**Jean Fraser - Munjoy Heights**

**From:** Jaime Parker <jaime@trails.org>  
**To:** Jonathan Culley <jonathan@redfernproperties.com>, Soren Deniord <soren@s...>  
**Date:** 11/14/2013 2:49 PM  
**Subject:** Munjoy Heights

RETAINING WALL TYPES

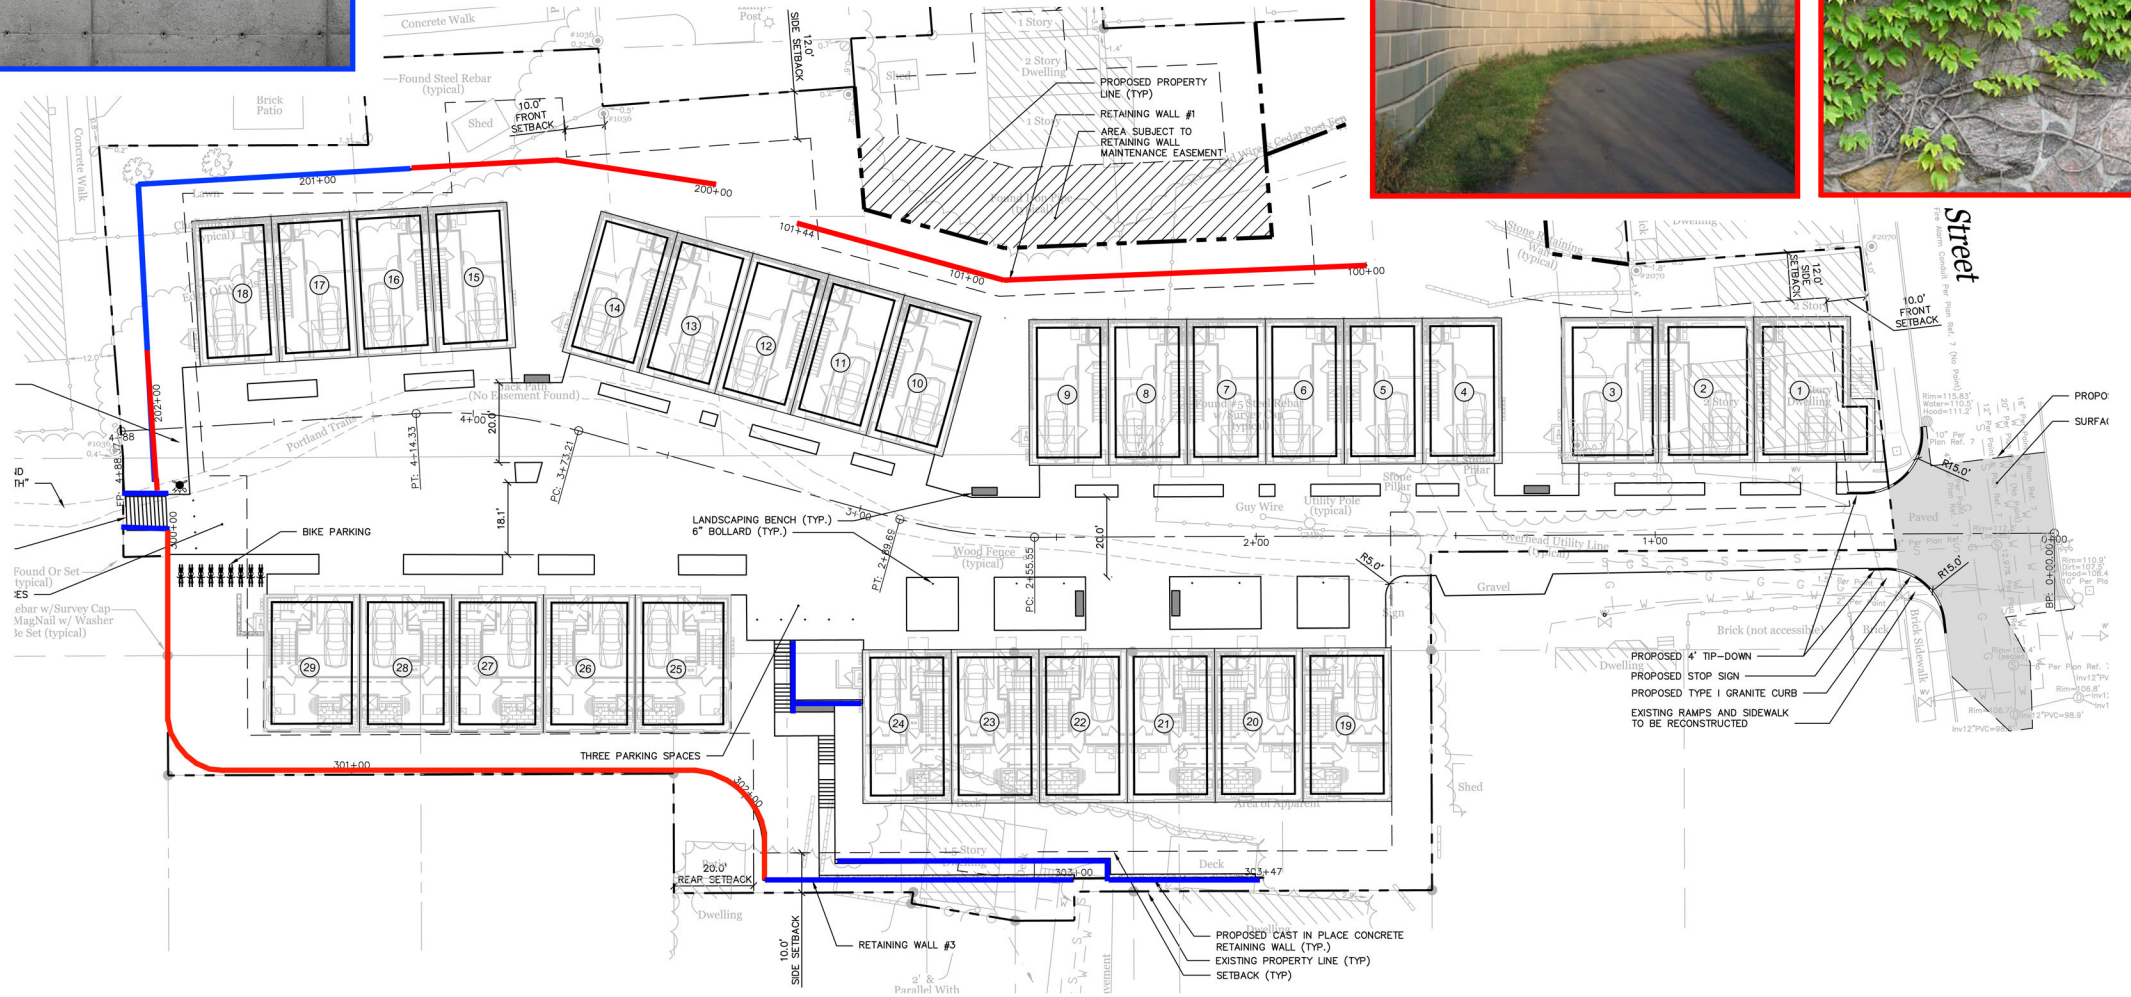
- Large wall as the 'terminal vista' down the street. Though a green screen may help, this is still visually daunting. A transition to natural materials (boulders...) might help. We understand the area below the wall is also a vehicle turning bay for the last house, and we assume this is one of the temporary snow dump locations...?...that would limit what else you could do there, but part of this area has the potential to be an extension of the trail node - movable benches, planters..... some vertical elements to break up the wall? We're just brainstorming, and you guys are the experts, but it seems there might be some multi-purpose treatment options here.

LANDSCAPE PLAN

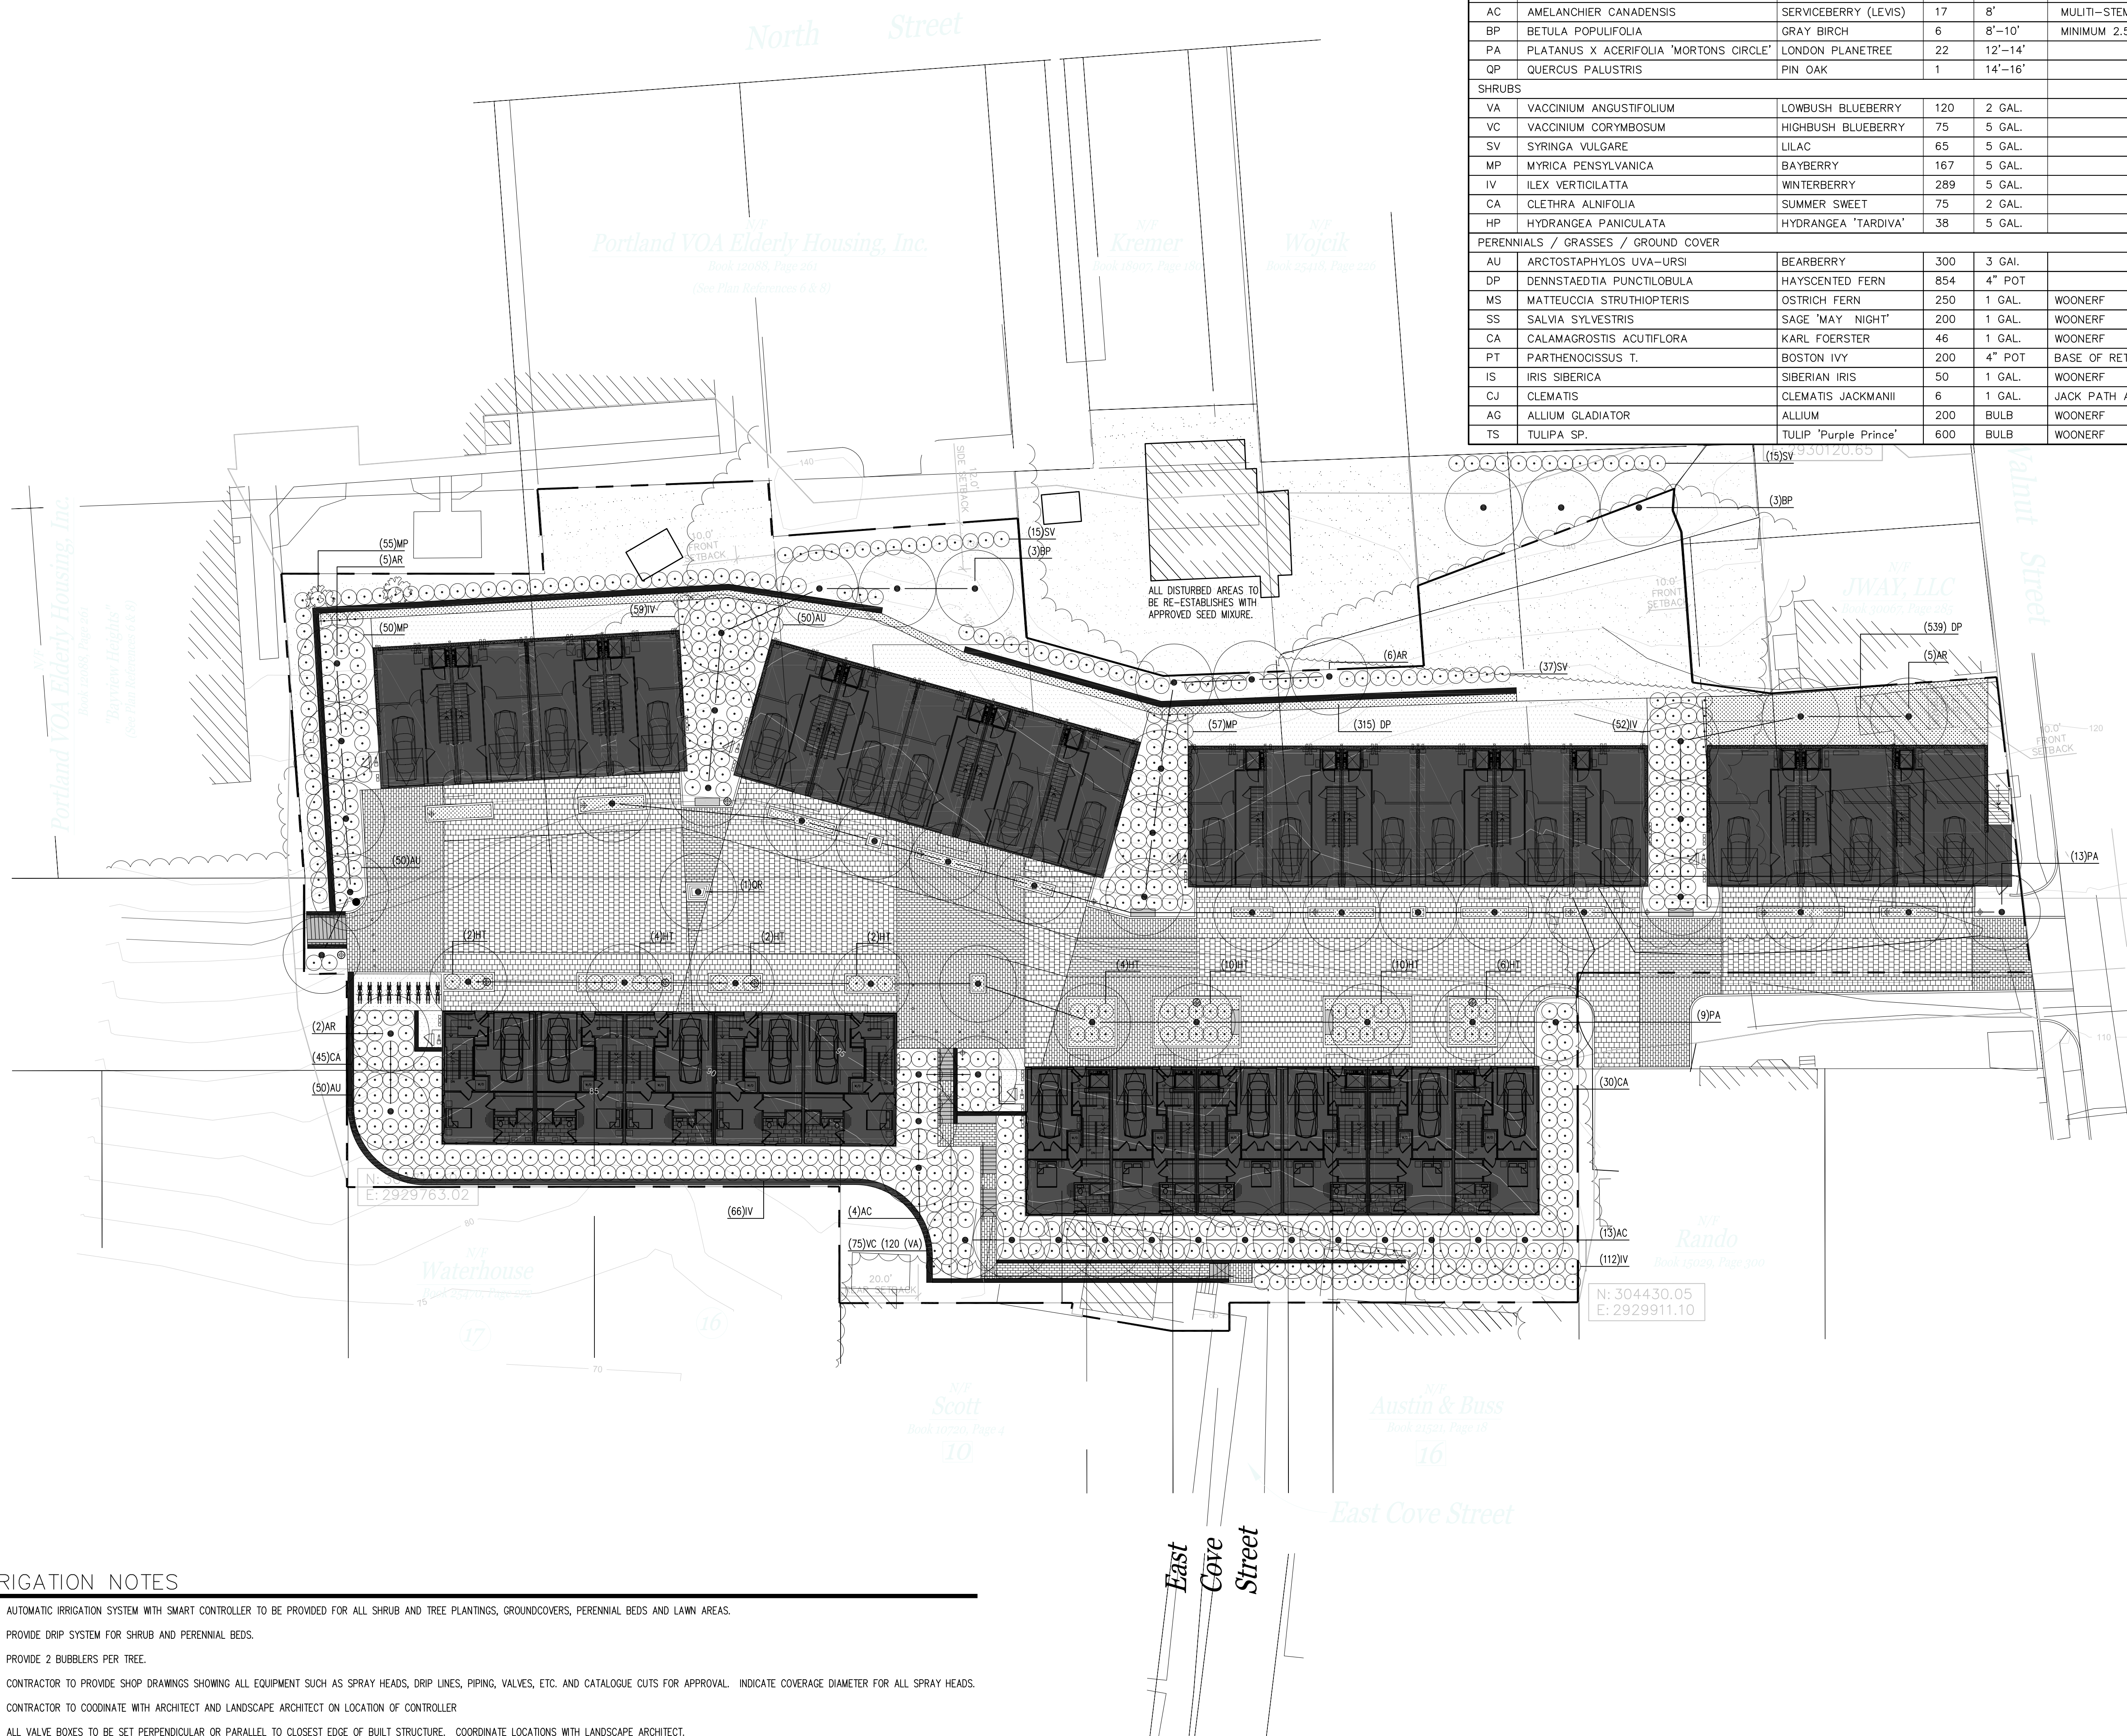
- Trail node at Jack Path - parked cars blocking visual access and compromising the pedestrian experience. Though we all think these spots may not be occupied much of the time, it would be unfortunate to find that they are occupied more often (by owners who may not want to pull into the garage all the time for example). It would be great to solve/mitigate this through design, and we look forward to seeing your latest thoughts on this. *[After writing this I saw the latest submissions to Planning, which show the bike parking near the trail head...which got me thinking, if you put the bikes elsewhere, could the cars be pulled far enough forward to not block the trail?.....could the steps be pushed any farther back to bring them more into the sight line and farther from the backs of the cars? ...]*

- We agree with Alex that if there are to be stairs to the Jack Path they should be a bit wider, maybe 6', and that there should be room for a bike ramp on the side. *[appears to be addressed in the new version - the bike ramp we can probably do 'after the fact', in the field.]*

- Trail to E. Cove - we're wondering if you have a stair/landing option where you showed a ramp. Something about the ramp seems less desirable...maybe it's more institutional? Seems more likely to be slippery too.

- At the top of the stairs from E. Cove - again you run into the parked car issue. Not sure what to do about it, other than to ensure there is a clear and welcoming path around both sides of the cars, to the woonerf. If this wasn't a place for cars, it would have GREAT potential as a larger node, given the elevation and view down E.Cove and over Bayside (great sunsets!). This can be done 'behind' the cars too, but won't be as much of a 'Place' as if you could incorporate the whole area.

- Bike racks - we still think there should be a few 'guest' bike racks/spots; ideally near the trail nodes. I would think these could be ornamental vertical elements that fit into the landscape, that happen to be good bike racks, rather than stand alone boring bike racks with requisite space-hogging concrete pads. *[see them in the new plans...they do take up valuable space...I've seen some 'wall mounted' types, and others that take less space...]*
